**KIRKLEES METROPOLITAN COUNCIL  
INVESTMENT & REGENERATION SERVICE**

Reference No:	<b>2024/62/93114/W</b>
Site Address:	21, Darnley Close, Meltham, Holmfirth, HD9 4BT
Description:	Demolition of existing garage and link structure and erection of two storey side extension with external alterations
Recommending Officer:	Joshua Merriman

## HOUSEHOLDER DELEGATED REPORT

Proposed Site Layout
Scale 1:500

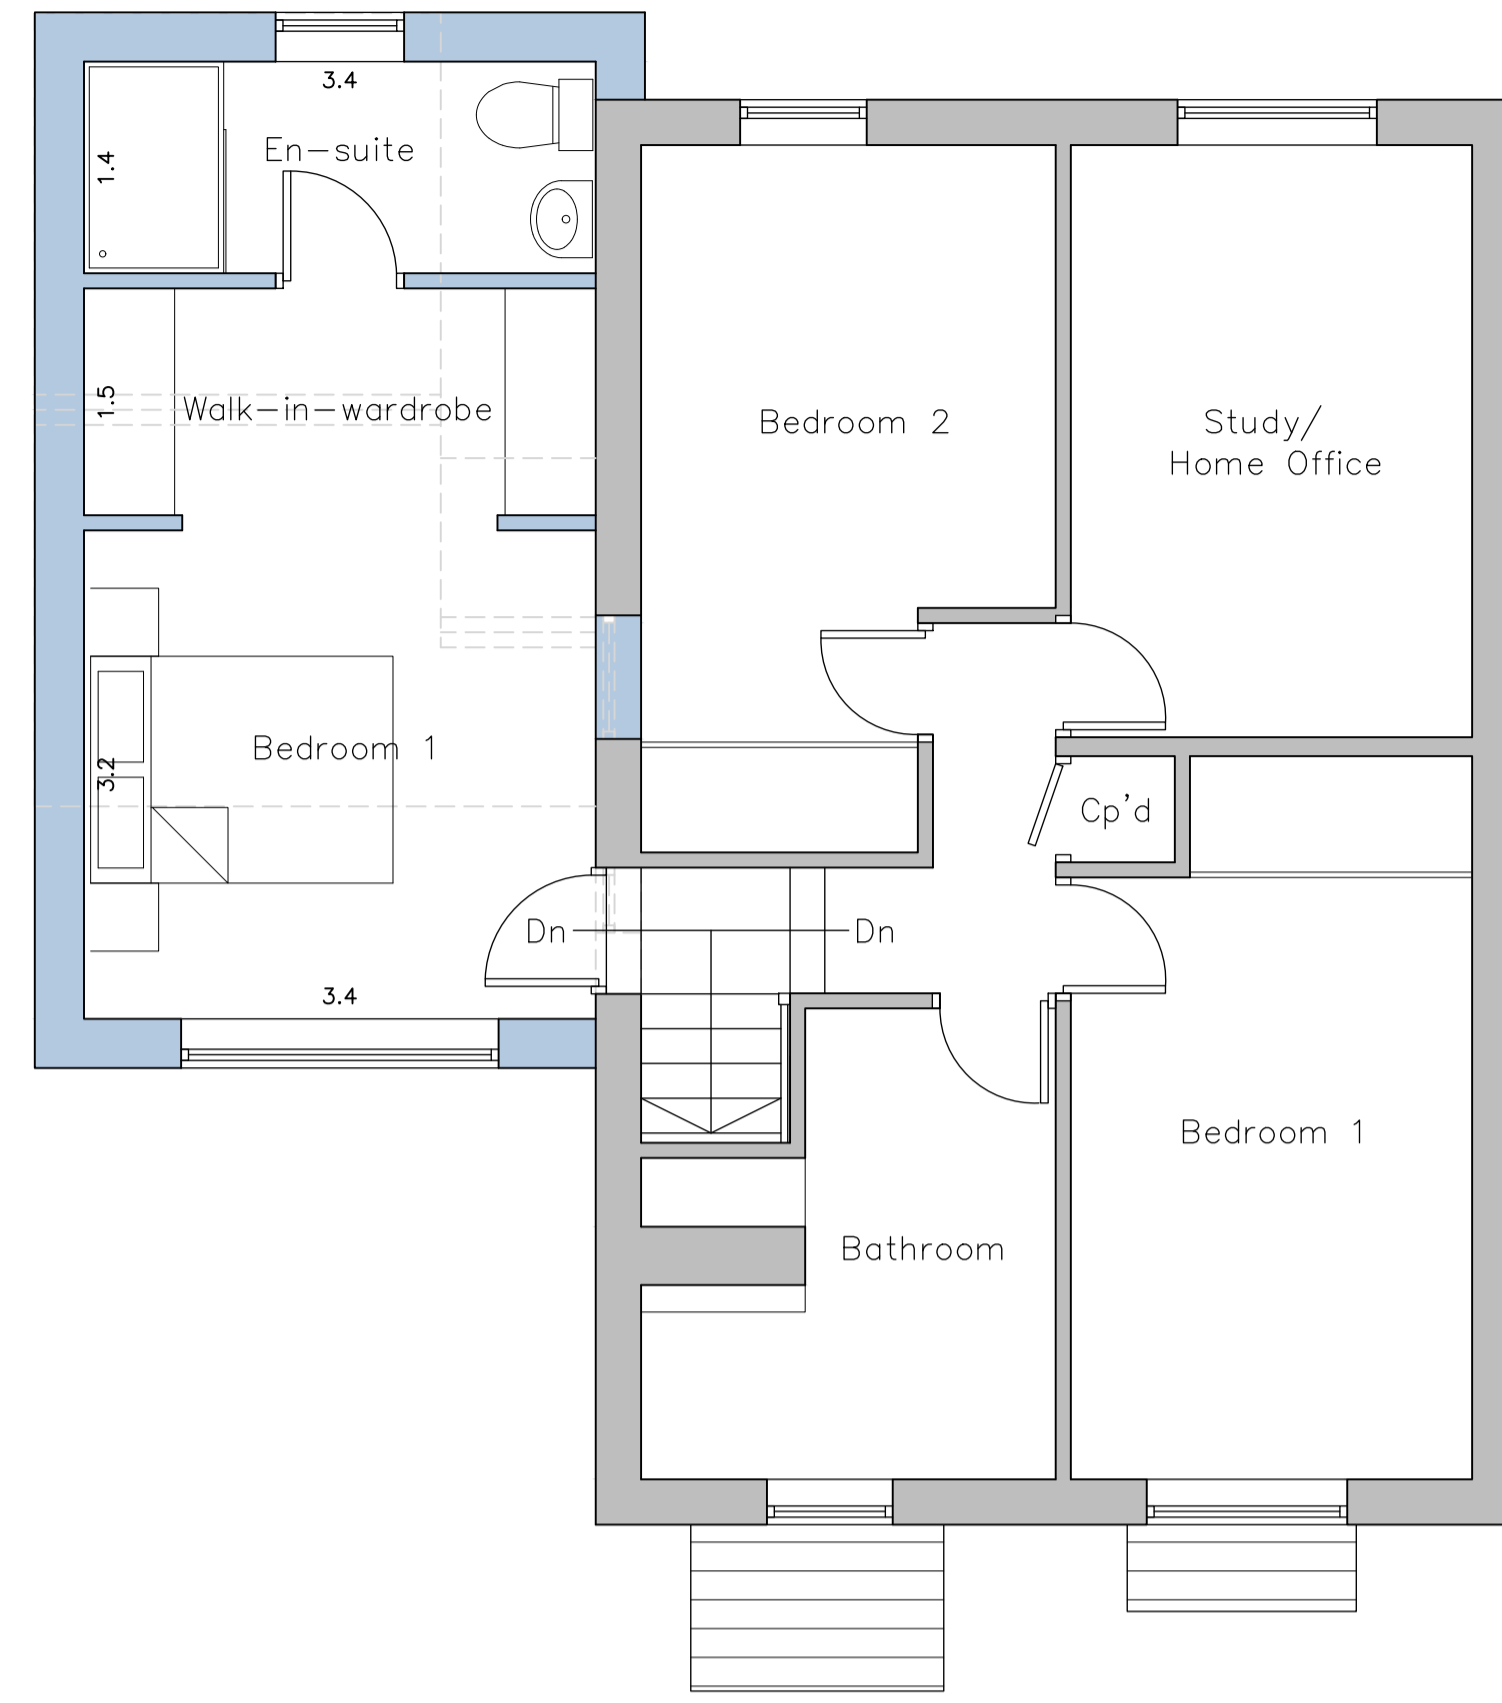
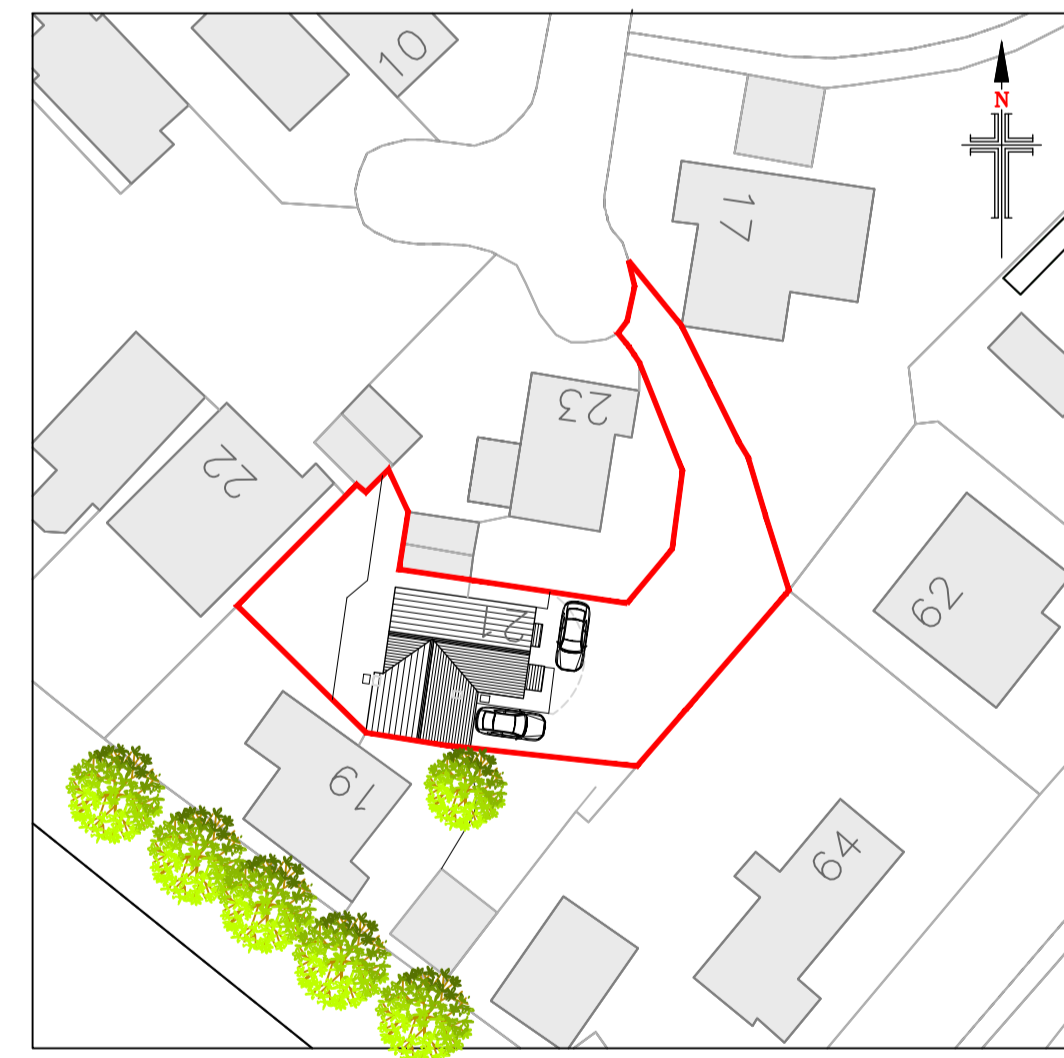
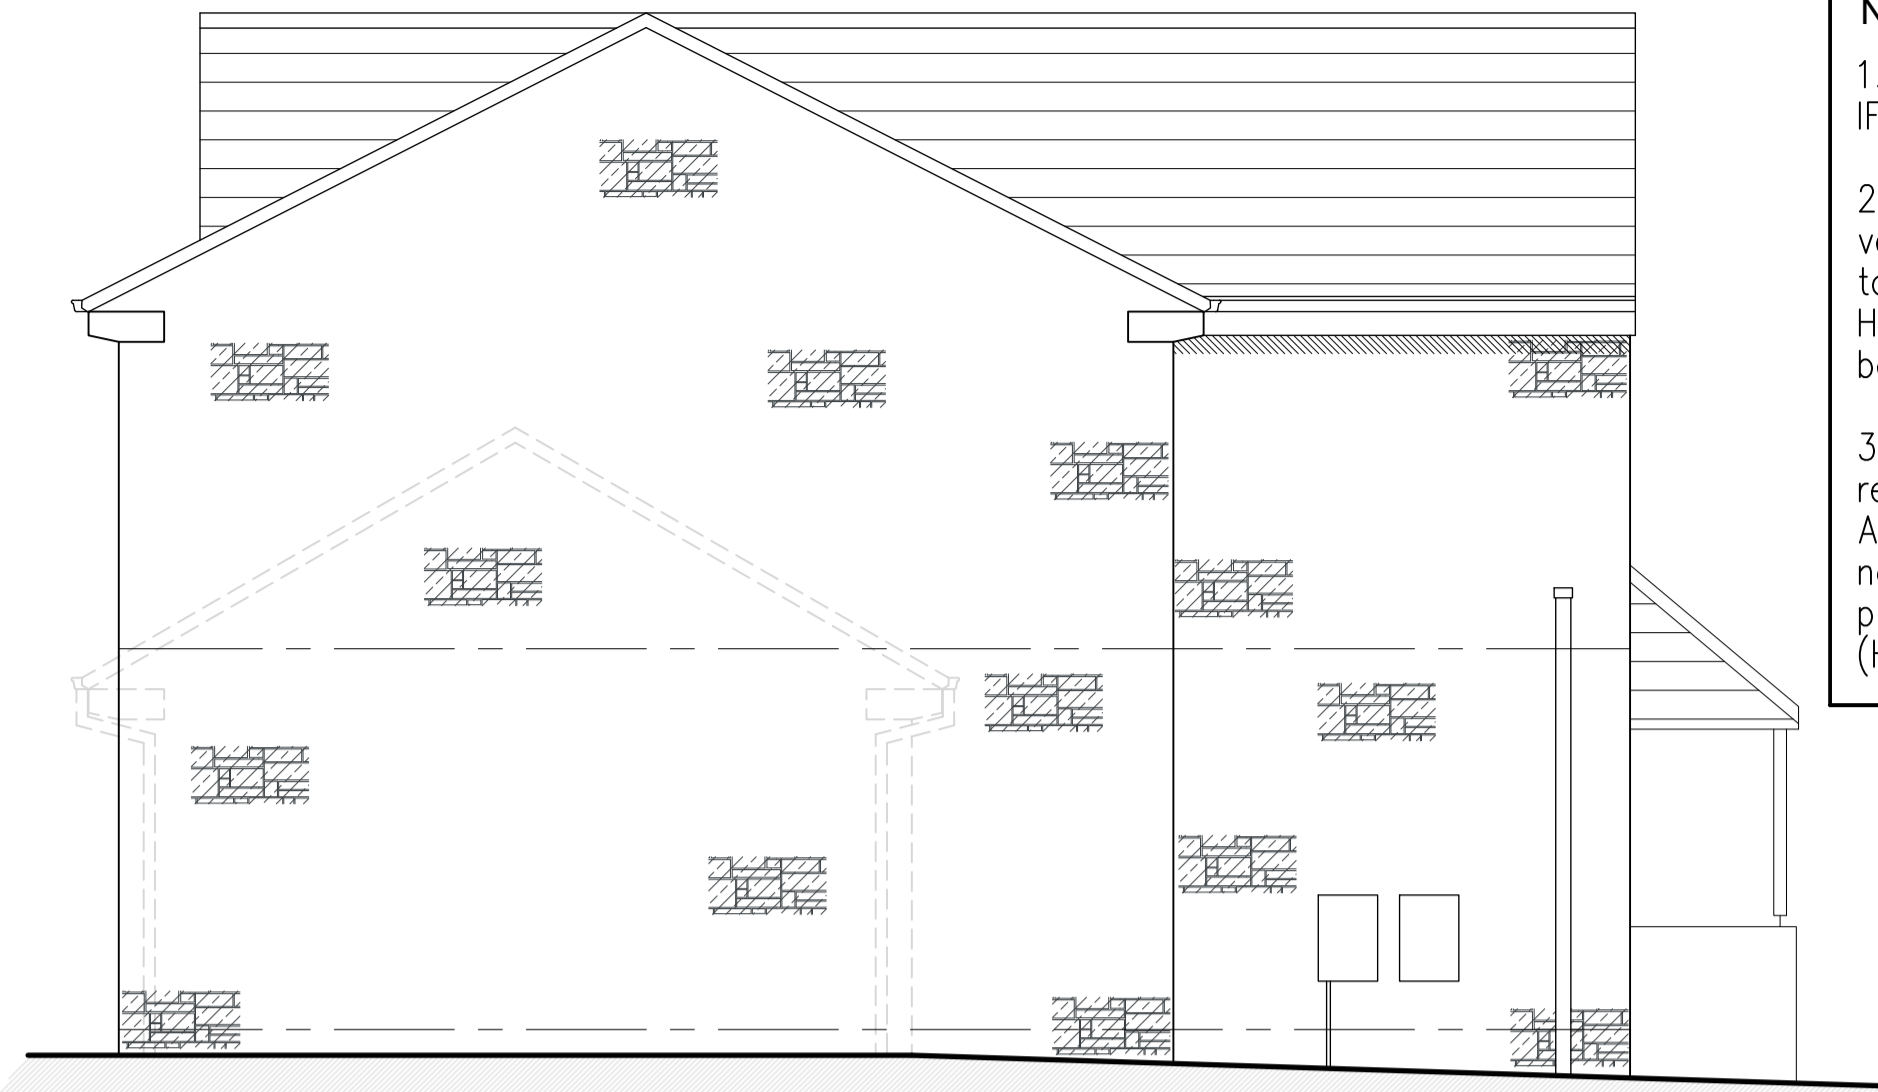
Summary of Representation	Officer response
Meltham Town Council have expressed their support of the application.	Noted.
The position of the third proposed parking space at the property would prevent other	New plans were submitted by the applicant moving this space to directly in front of the application property, with the car at a different orientation.

vehicles from easily manoeuvring into their own spaces via the shared driveway.	
The extensions frontage being extended forwards would potentially obstruct footpath access to the neighbouring property No.19.	The impact of the development upon a right of access across the site by a third party is a consideration which is afforded minimal weight in the determination of this application. This would constitute a civil matter between the respective land owners, and suitable legal agreement(s) entered into. An informative note advising that any grant of permission does not override existing legal covenants / rights of access is recommended to be included upon any grant of permission.
Overlooking of neighbours	An assessment of the impact of the development upon overlooking is set out in the 'Residential Amenity' section of this report.
The practicalities of the building works could result in damages to the front garden of No.19.	Potential damages as a result of the construction process is a matter which can be afforded little weight given it would relate to a matter which can be controlled by separate legislation should such an occurrence take place.

Scope to provide a third space horizontally	The amended plans the subject of this application demonstrate such a parking arrangement.
Deeds have a clause relating to amendments to the facade of the building and requirement for permission from the original developers	It is considered this is a legal matter to which little weight can be afforded by the LPA in the determination of this application.
Concerns would be alleviated if the proposal was for a first floor extension above the existing garage	This application is assessed on the basis of its own merits.
